North Littlehampton, Fitzalan Link S278 Works

Stage 1 RSA – Road Safety Audit Addendum Response Report

1.1 This report results from receipt of a Stage 1 RSA Addendum Report, undertaken dated August 2017.

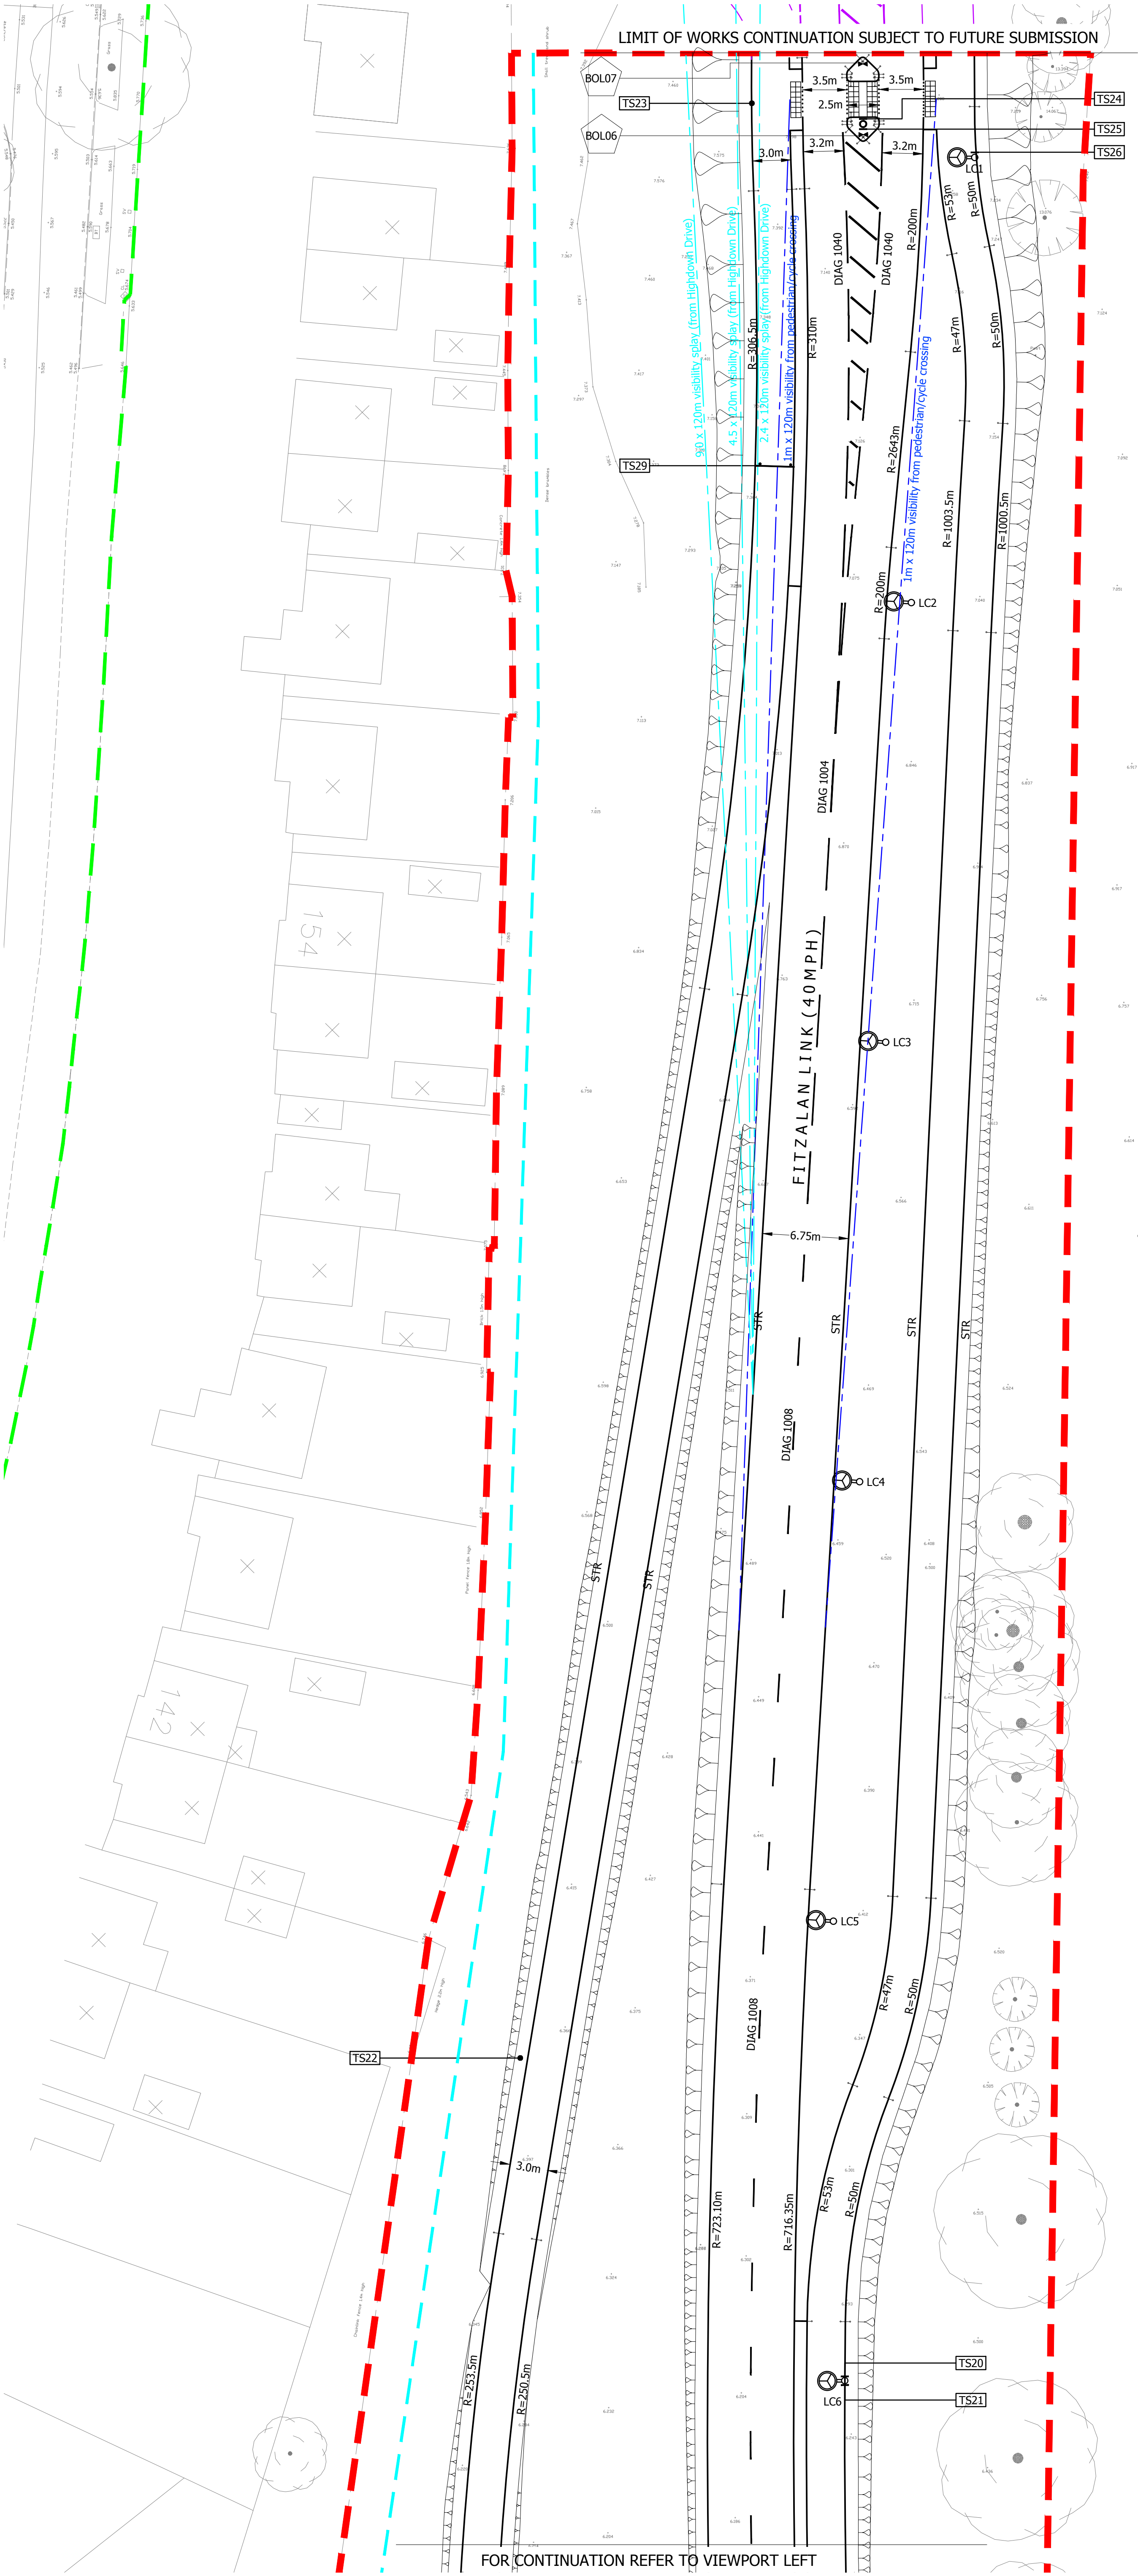
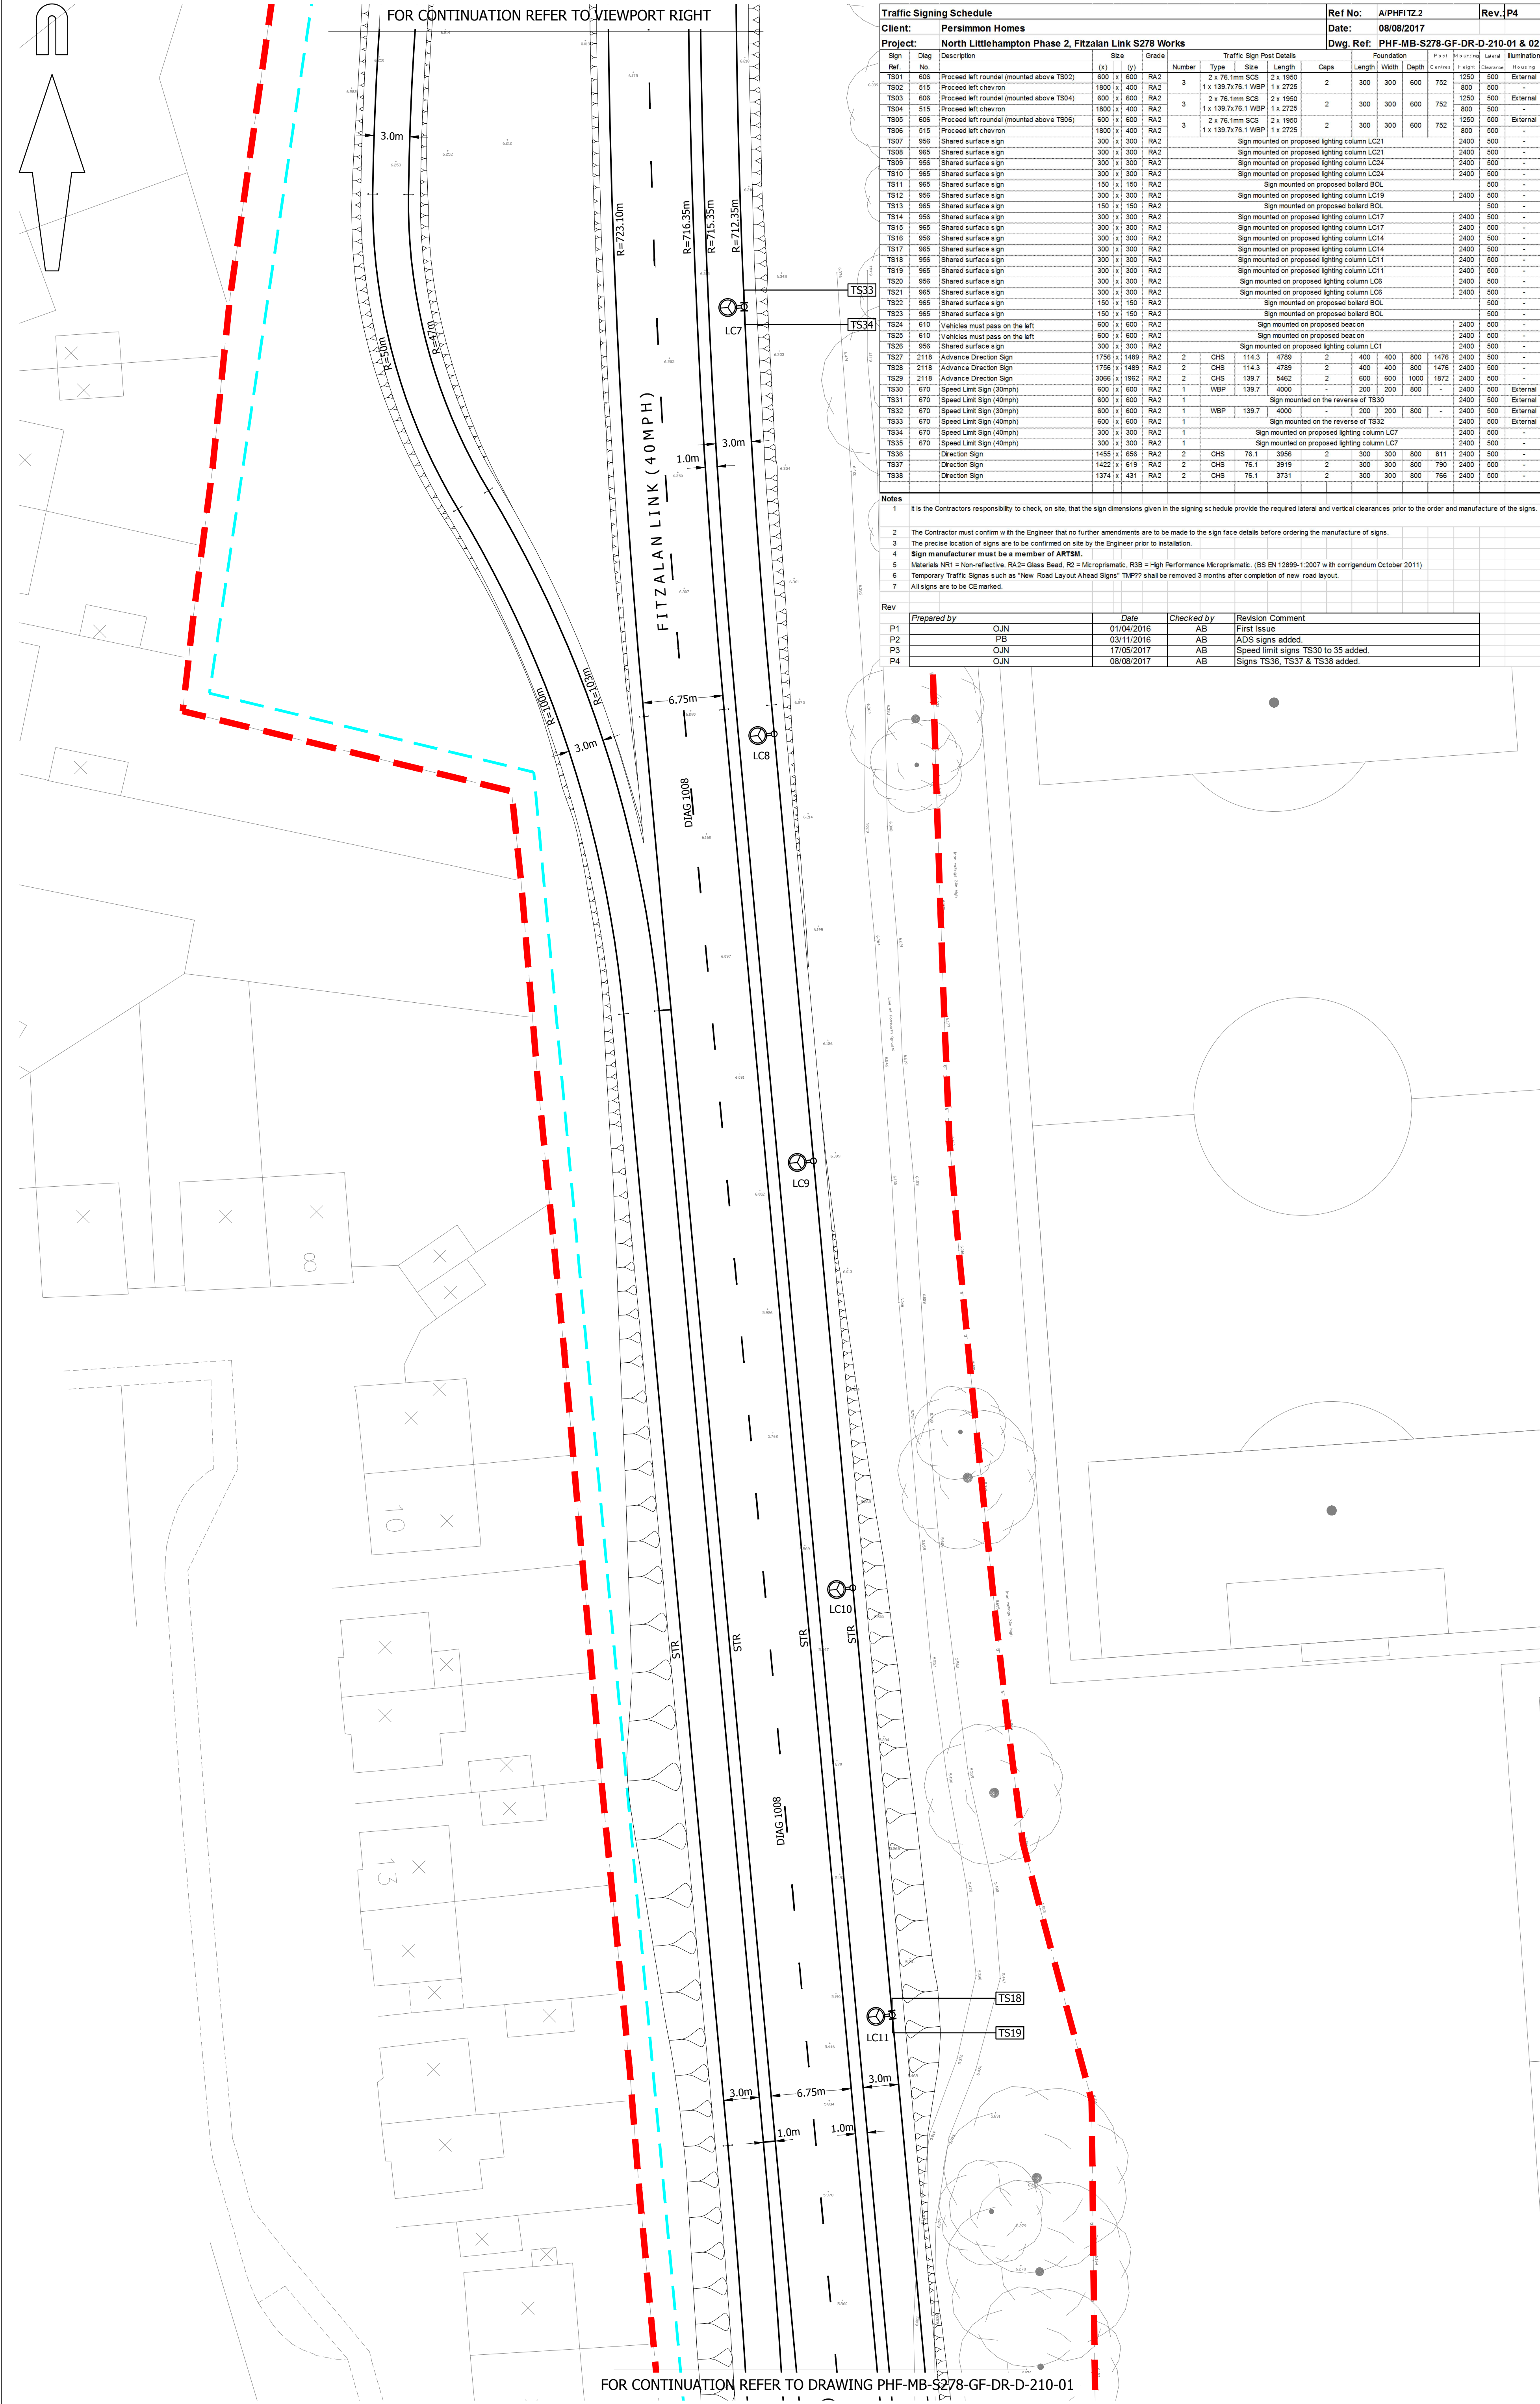
Item	Problem	Recommendation	Designer's Response
2.2	Location: General Summary: Proposed Signage It will be important that the new highway network is clearly signed throughout	I. Provide map-type signing on each approach to the new roundabout junction. II. Ensure adequate forward visibility to signs, and ensure adequate clearance between sign face and carriageway. III. Where appropriate ensure adequate clearance for pedestrians and cyclists beneath sign face.	Accepted. General arrangement drawing has been updated to show indicative signing positions, exact sign destinations, locations and sizes will be agreed with WSCC at detailed design.

2.3	Location: Proposed Roundabout Junction Summary: Junction 'see through' Details of chevron signing on the roundabout central island have not been submitted at this stage. It will be important that a "see through" effect is not created which could result in drivers overshooting the circulatory carriageway and central island.	Ensure "see through" is prevented by suitable provision and location of chevron signs and / or other features.	Accepted. The general arrangement drawing indicates chevron and proceed left signage on each approach to the roundabout as recommended. In addition it is proposed to suitably soft landscape the central island where visibility permits.
